James Irwin Charter Academy
Traffic Impact Study
(LSC #S224370)
PCD File No. COM-2222
September 7, 2022

Traffic Impact Analysis

RE: James Irwin Charter School
Traffic Impact Study
El Paso County, Colorado
PCD File No. COM-2222
LSC #S224370

Figure 16a
**Loading/
Unloading
Areas
(Short-Term)**

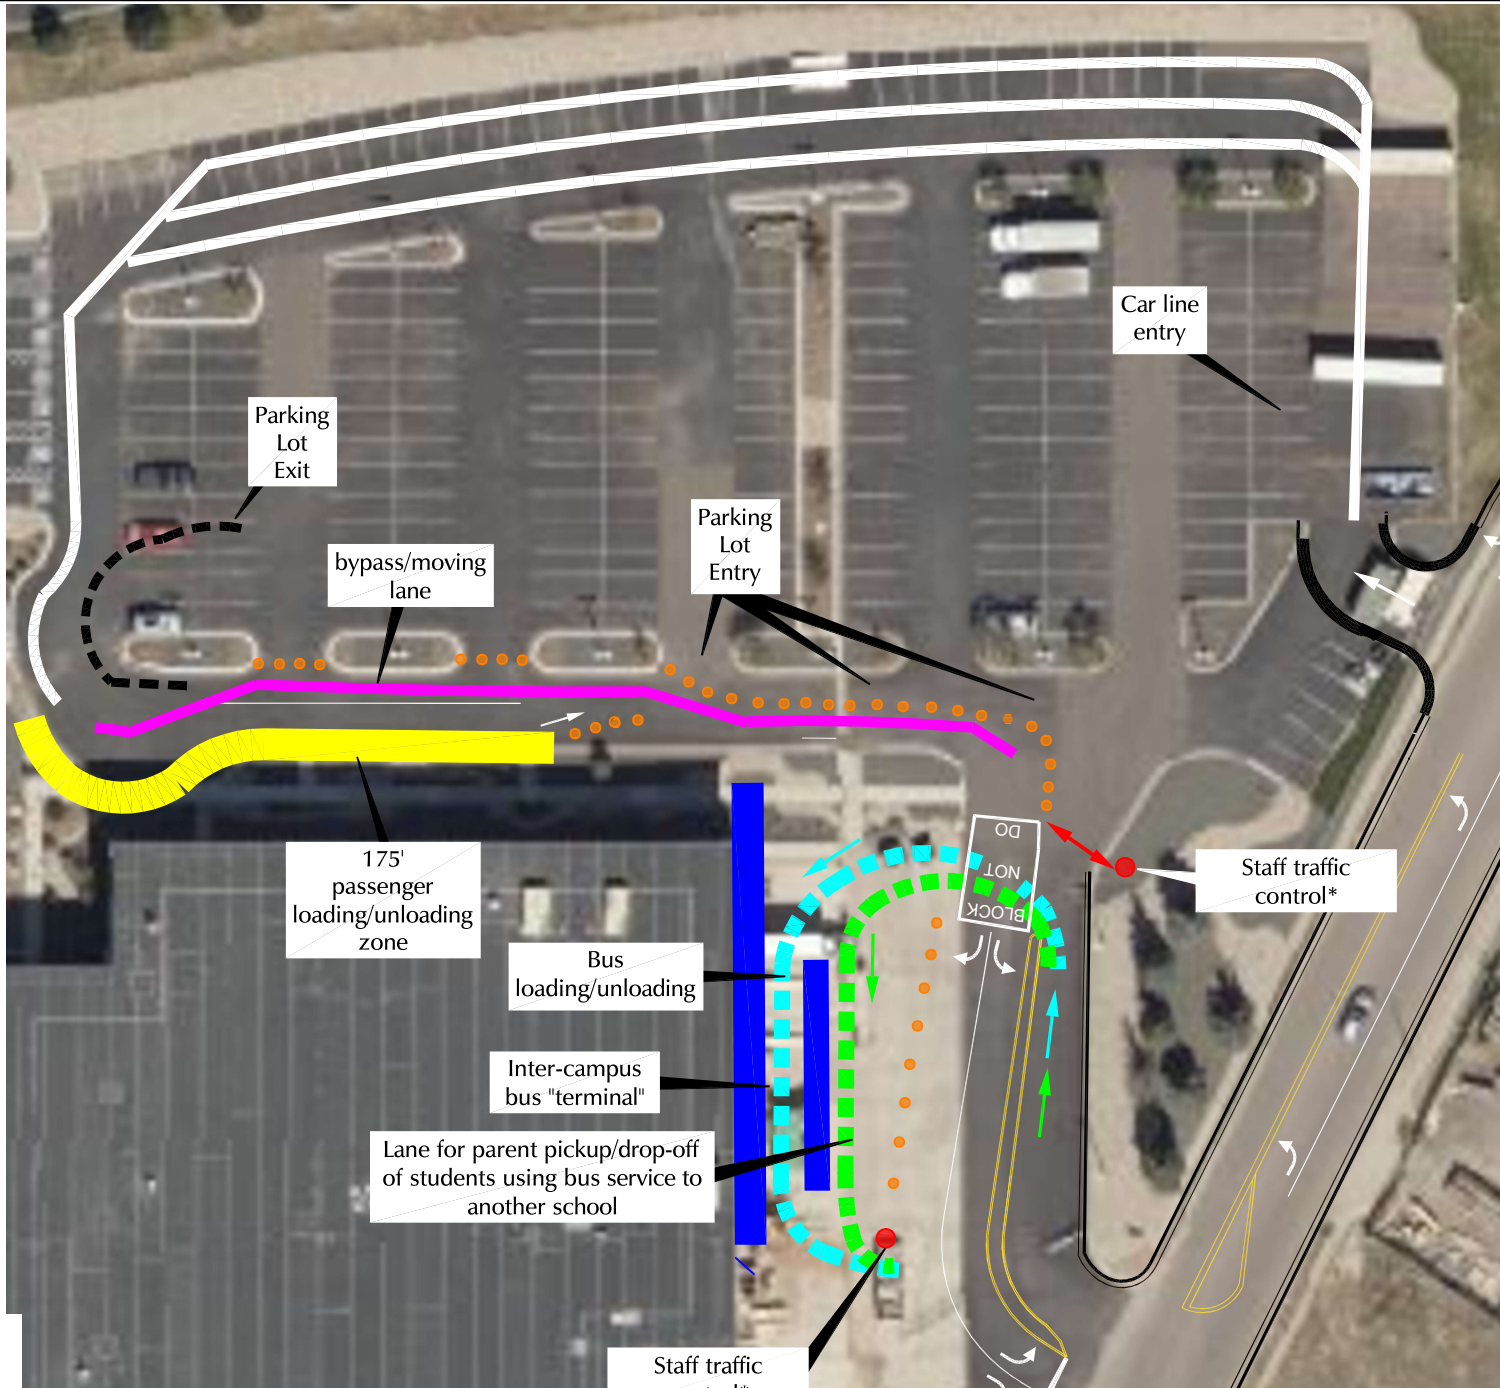
Unresolved. Explain how the buses will maneuver into the drop site when there are several buses arriving/leaving within a 15 minute window. The drop off site appears to not have enough room for buses to wait and not block access point.

Appendix Figure 1 - ZIP Code Data

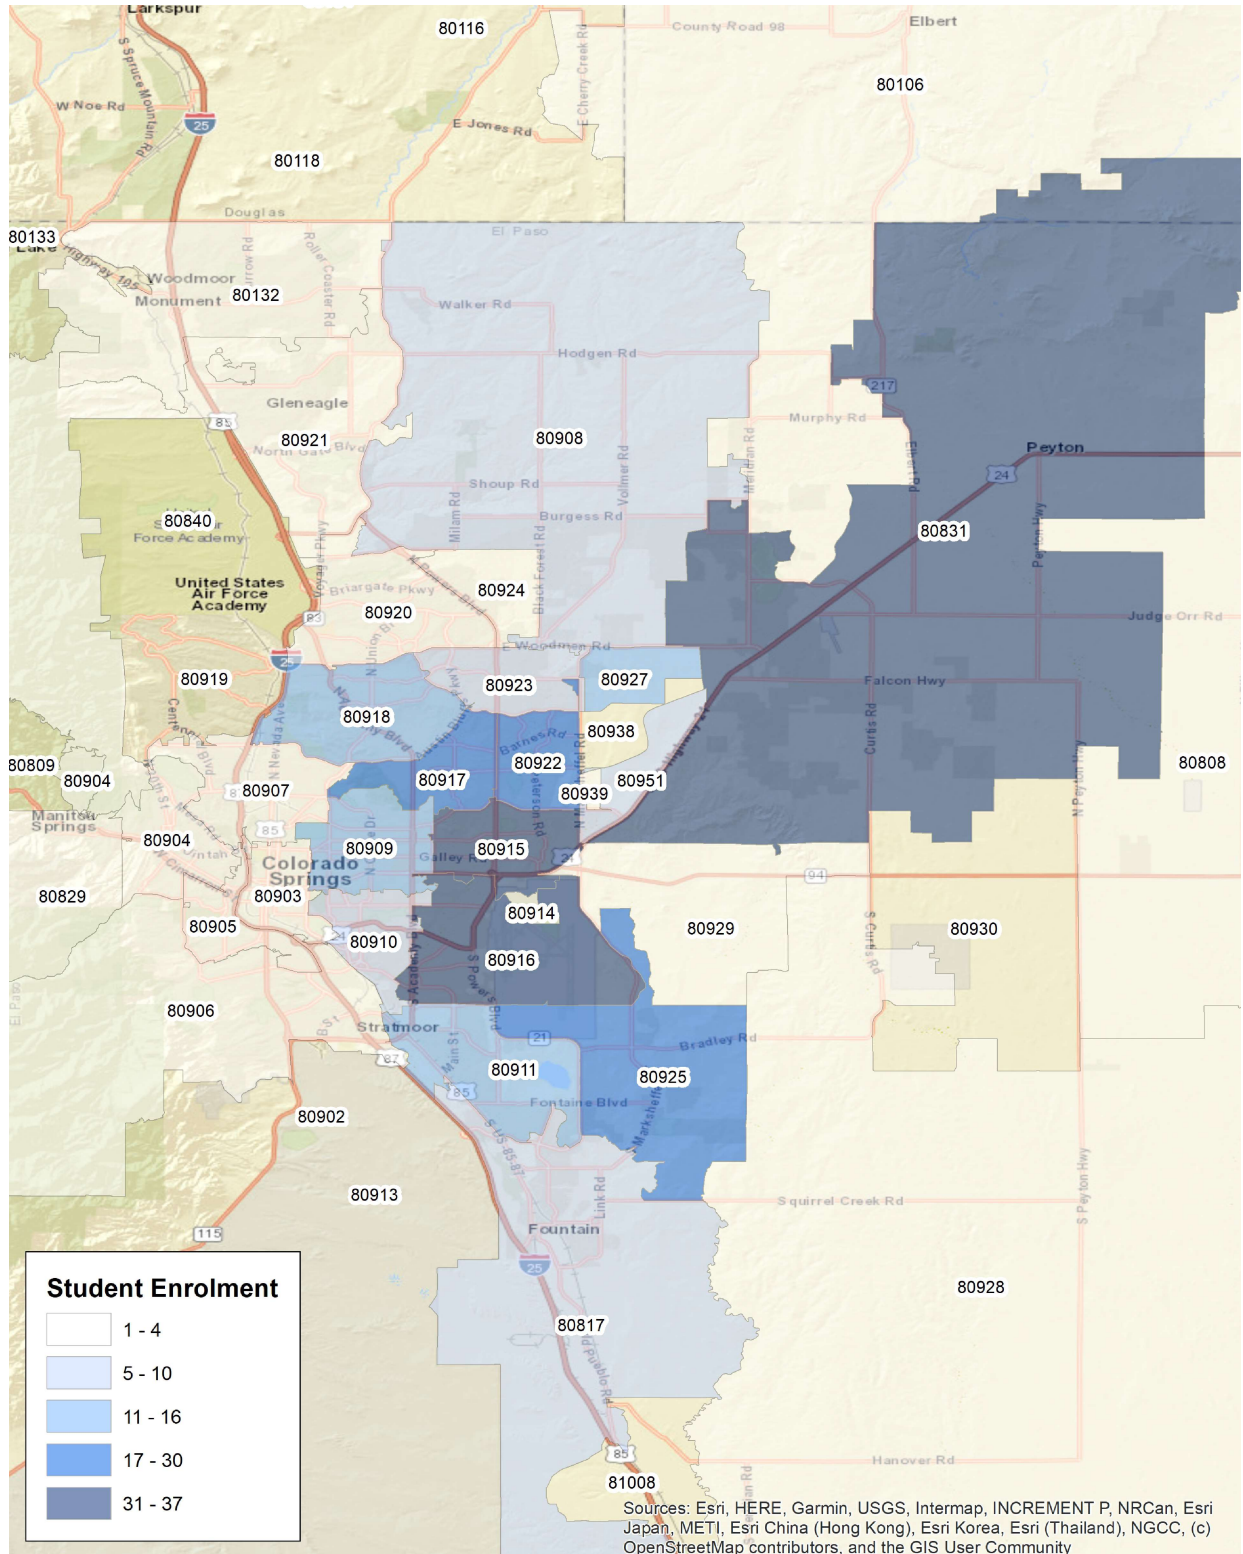
Revise to include zip code information since it is not in the appendix.

Figure 3a
**Sight Distance
 Analysis - North
 Access**

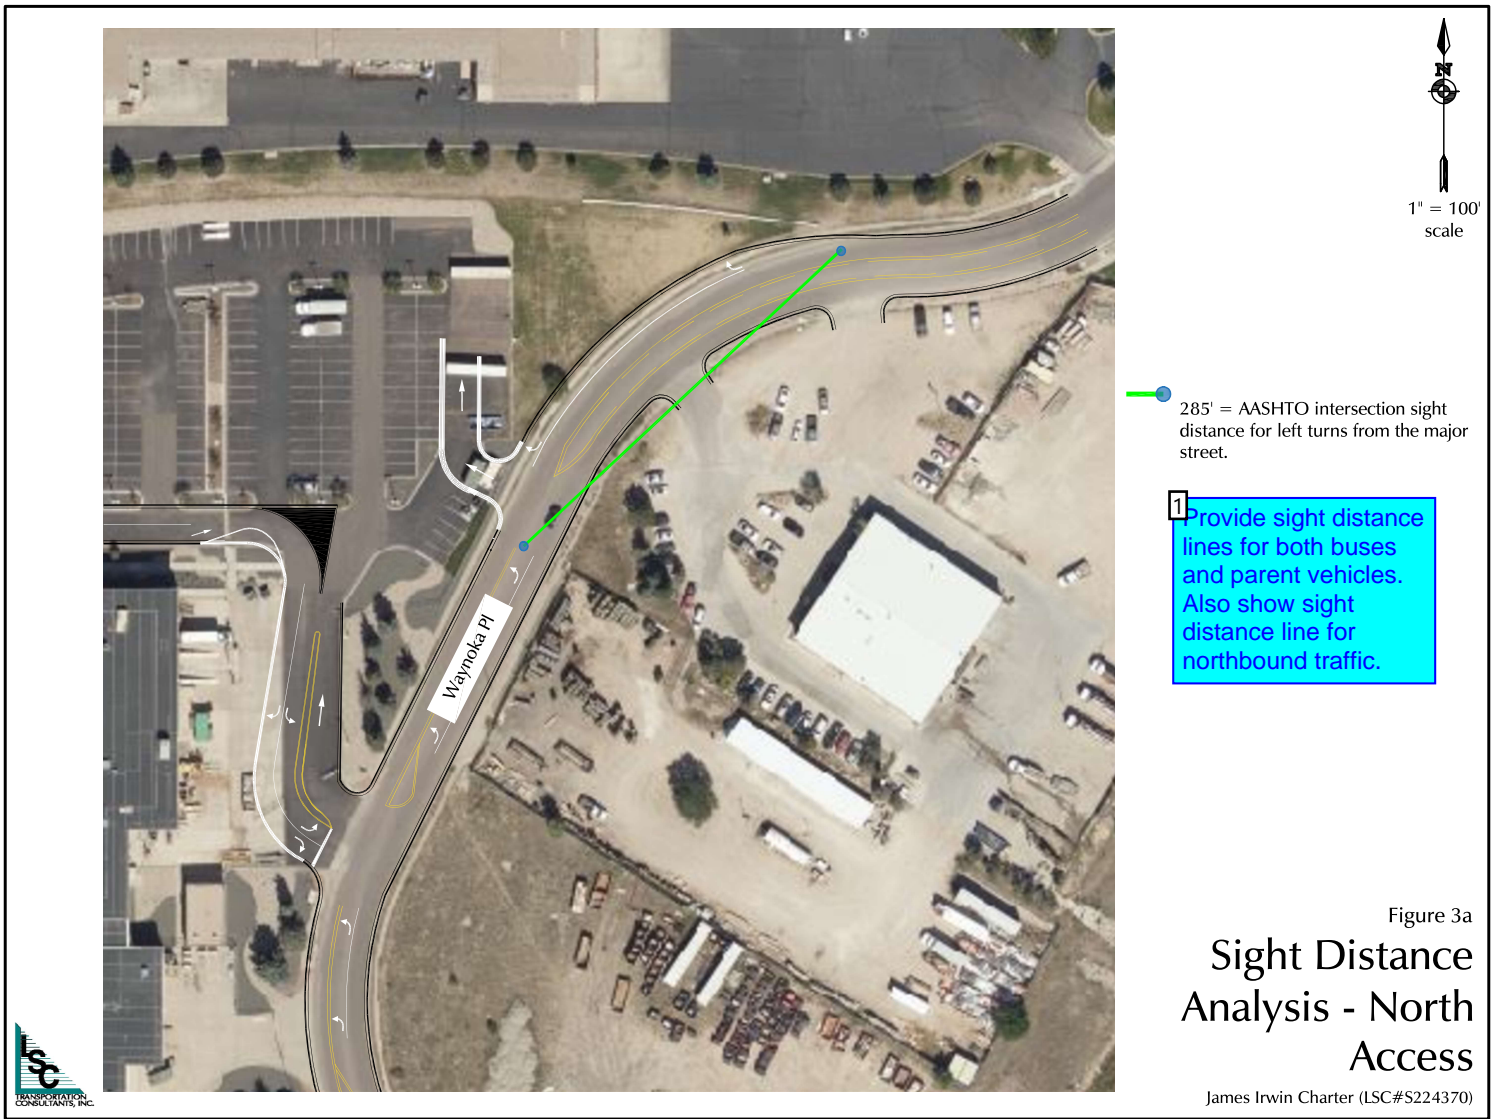
Discuss applicable ECM criteria and design vehicle for site distance calculations.
